# CLEVE HILL SOLAR PARK

# **SCOPING OPINION:**

## Proposed Cleve Hill Solar Park

**Case Reference: EN010085**

Scoping Layout

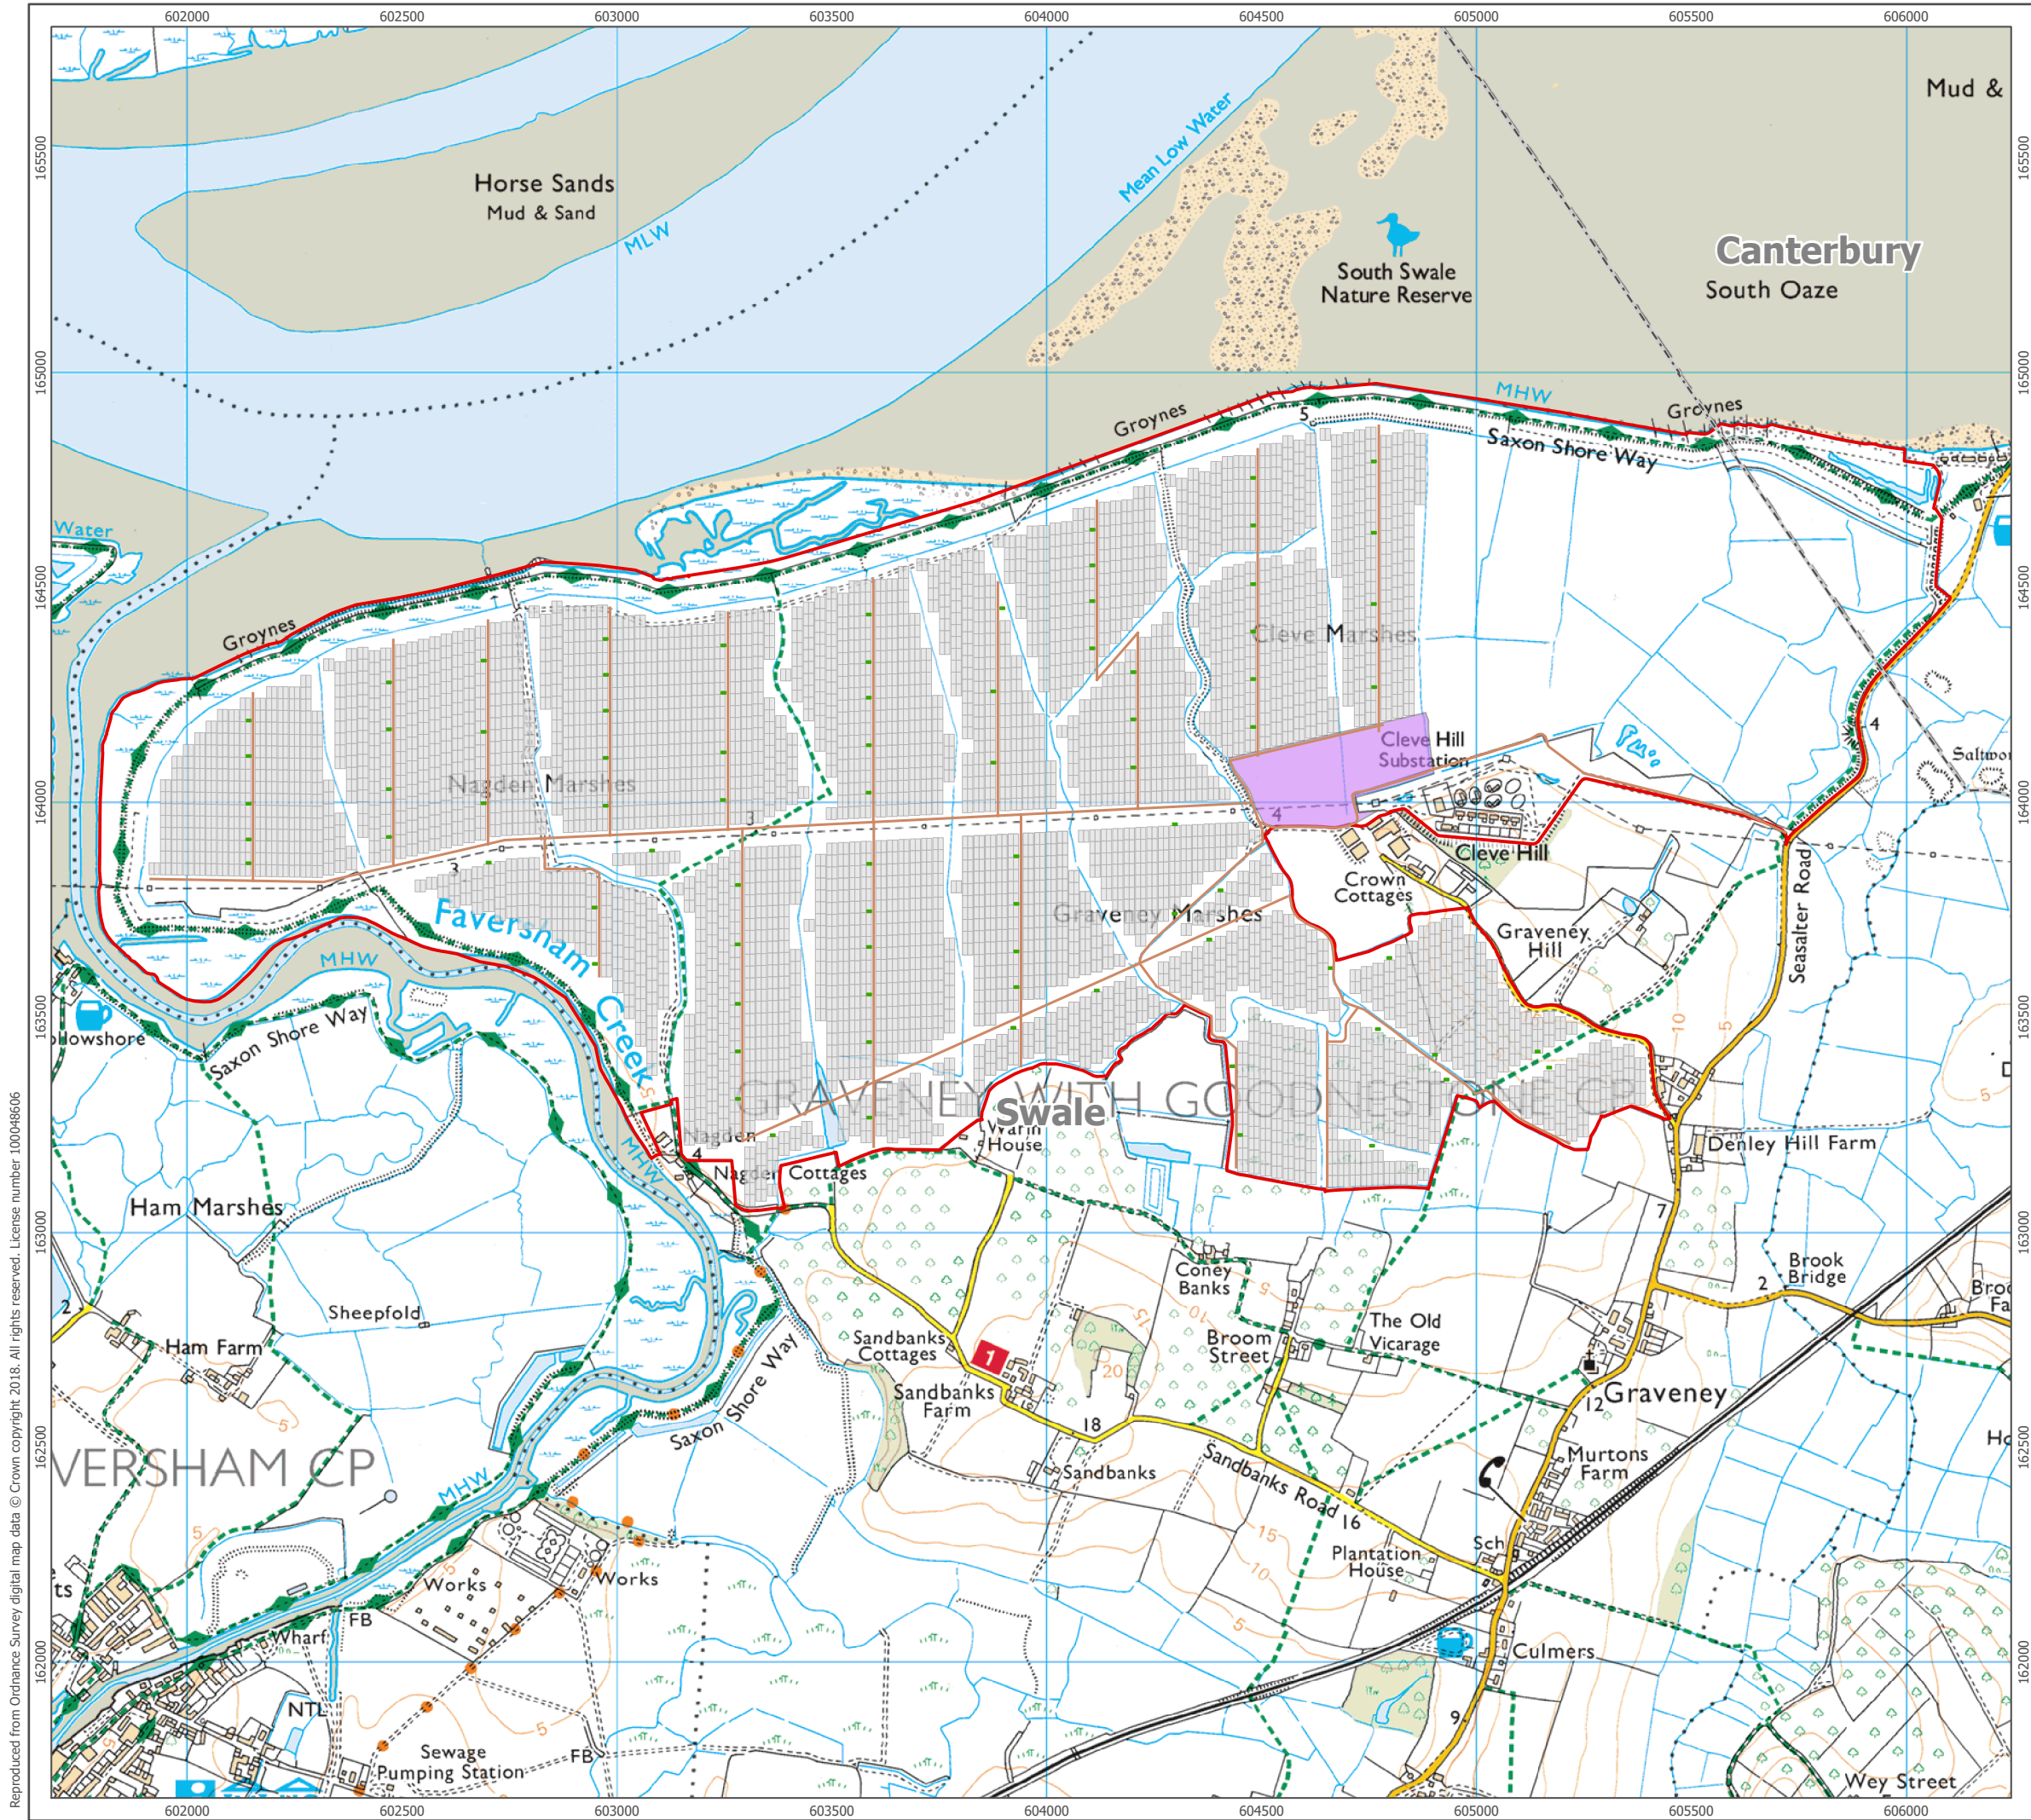
- 2.3.8 Figure 2 of the Scoping Report usefully identifies the proposed land uses within the application site boundary. The Inspectorate advises that a similar figure should be provided within the ES, ensuring all areas within the application site boundary are clearly labelled with proposed land uses. For example, with reference to Figure 2, the proposed land uses of the north-easterly section of the application site, as well as the area to the south of Crown Cottages, is unclear. This should be clarified in the ES.
